The Planning Inspectorate

Reference: OR-0011572/01

02 October 2026

ENVIRONMENT AGENCY COMMENTS ON ANY INFORMATION RECEIVED AT DEADLINES 1 AND 2 AND ACCEPTED BY THE EXAMINING AUTHORITY. LIGHT VALLEY SOLAR.

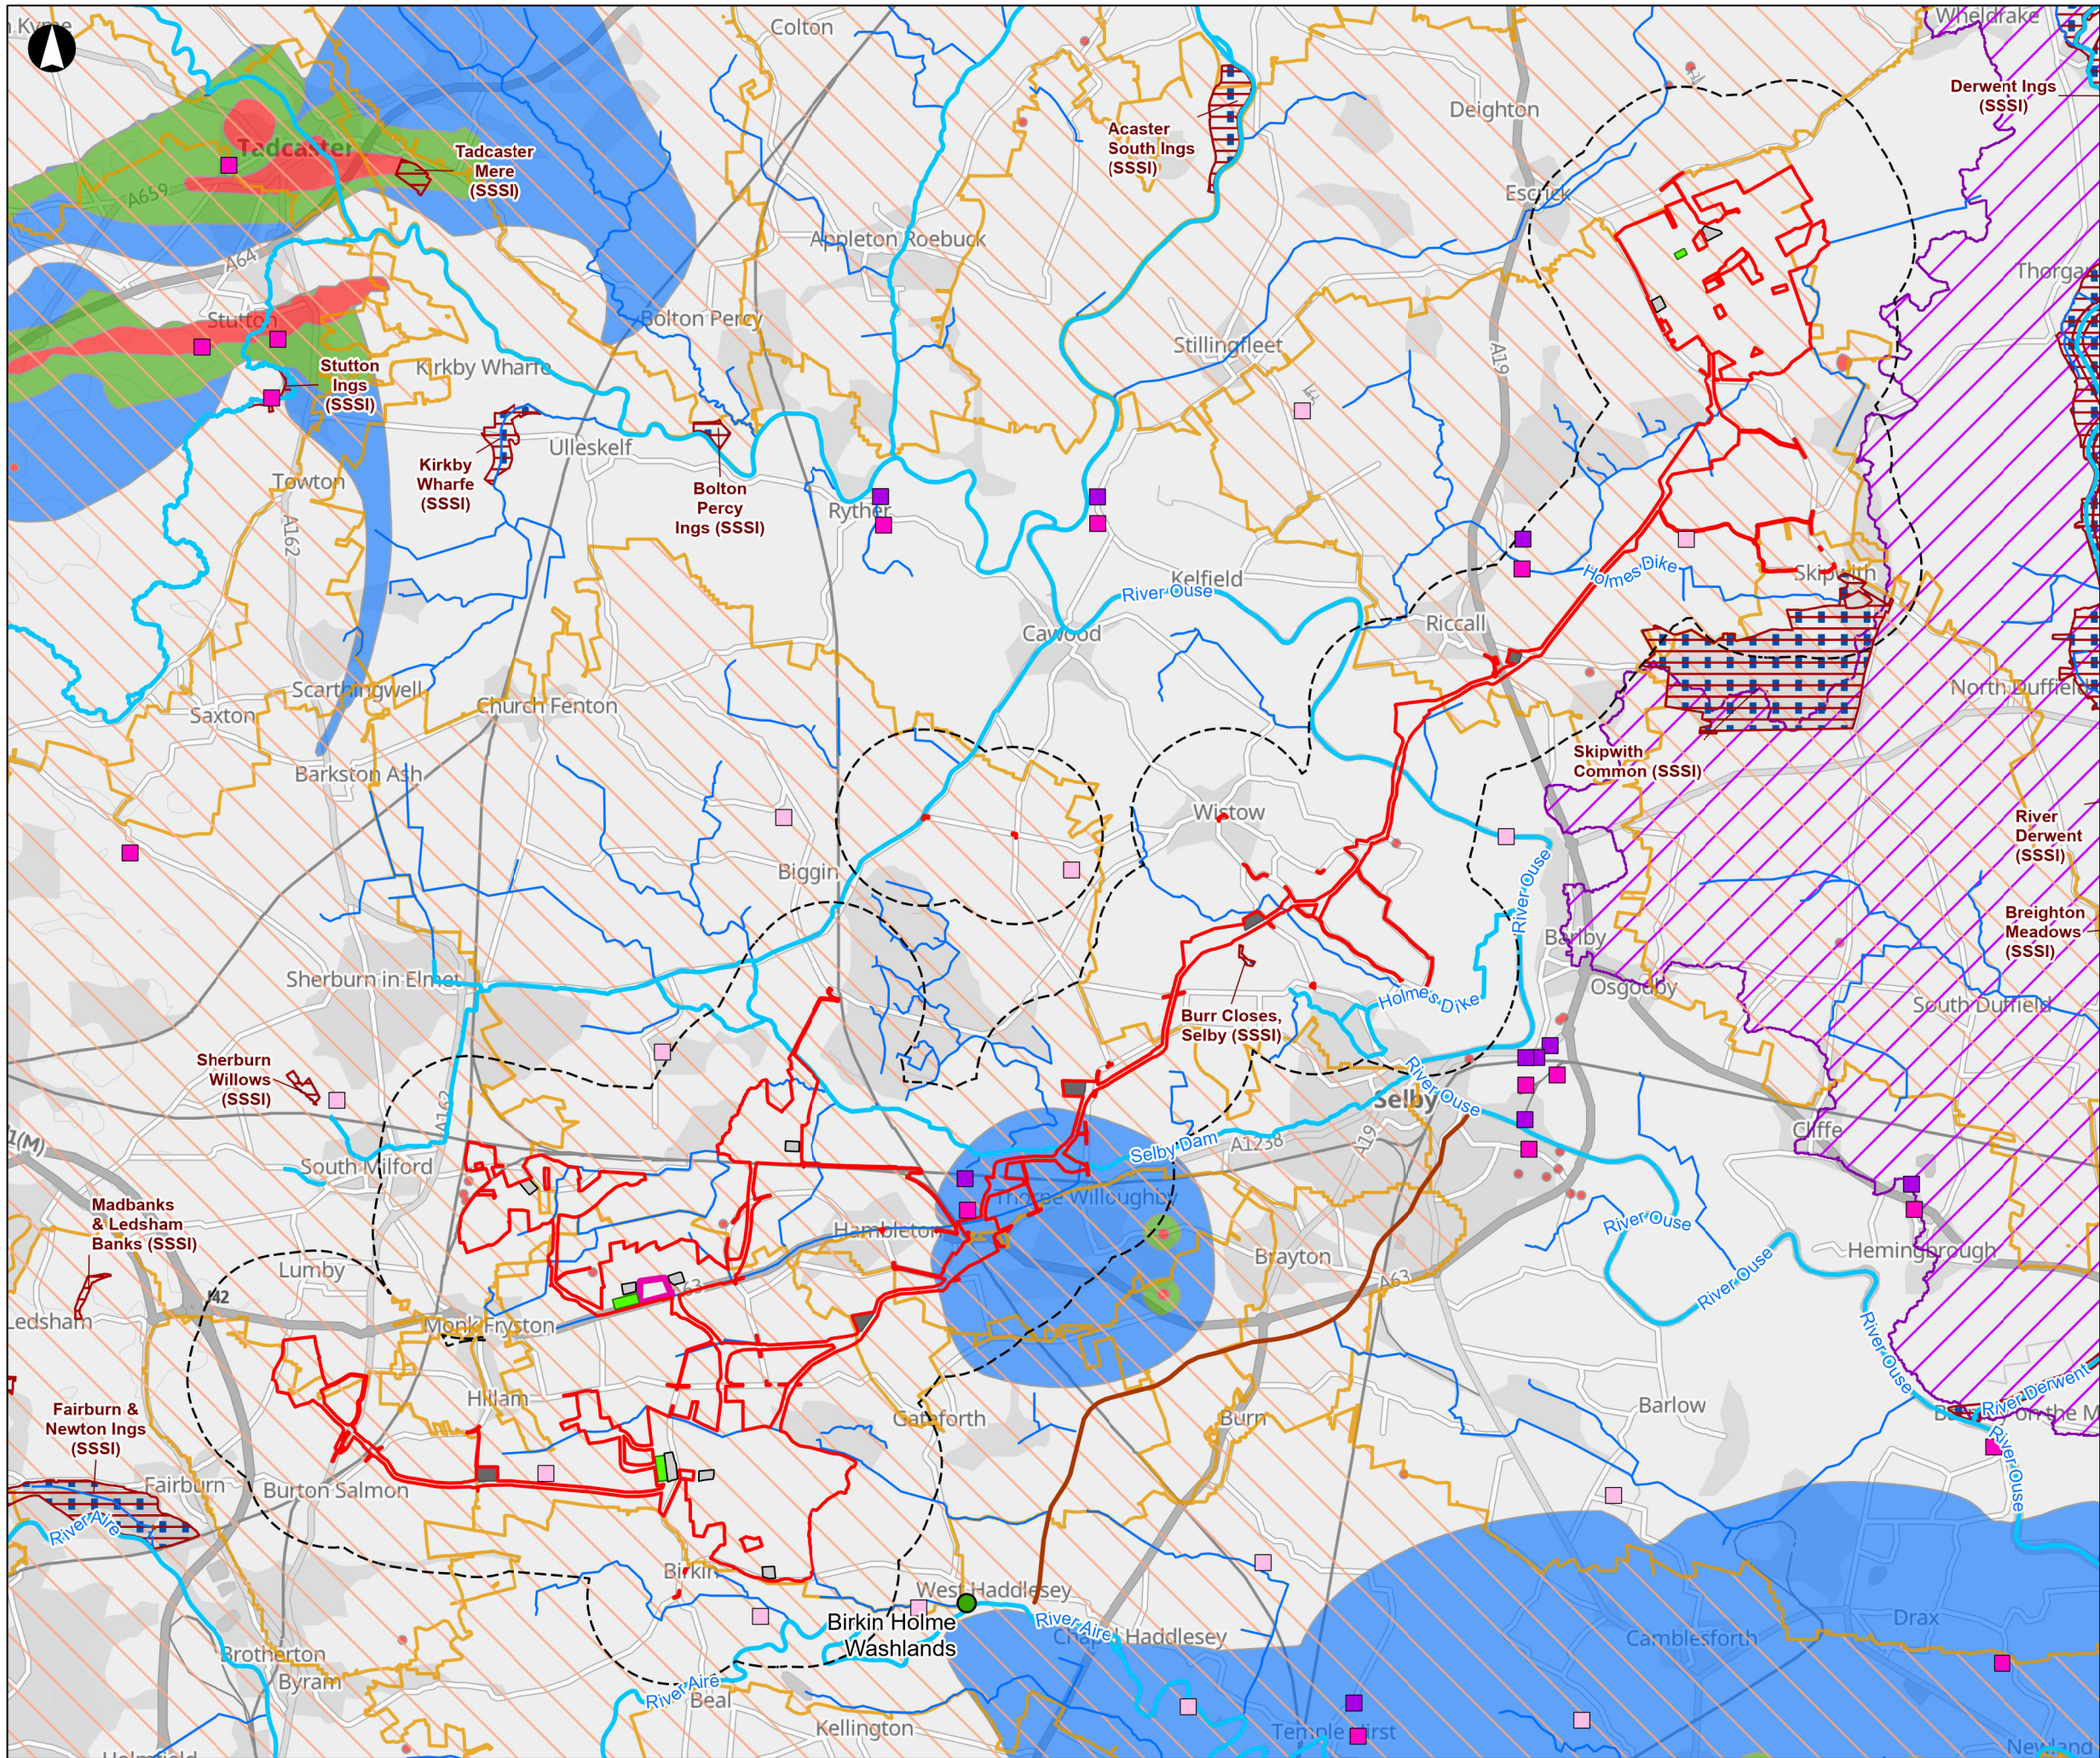
We wish to point out that the key for Figure 15.4 Groundwater and Surface Water Designations [[REP2-052](#)] shows a Drinking Water Safeguard Zone (Groundwater) marked as a purple diagonal hatch, but this designation is incorrect. The area marked in purple on the Figure is a Drinking Water Surface Water Safeguard Zone (Elvington & Loftsome Bridge). The Figure also does not show the following designated areas, which lie within the area shown within the viewport:
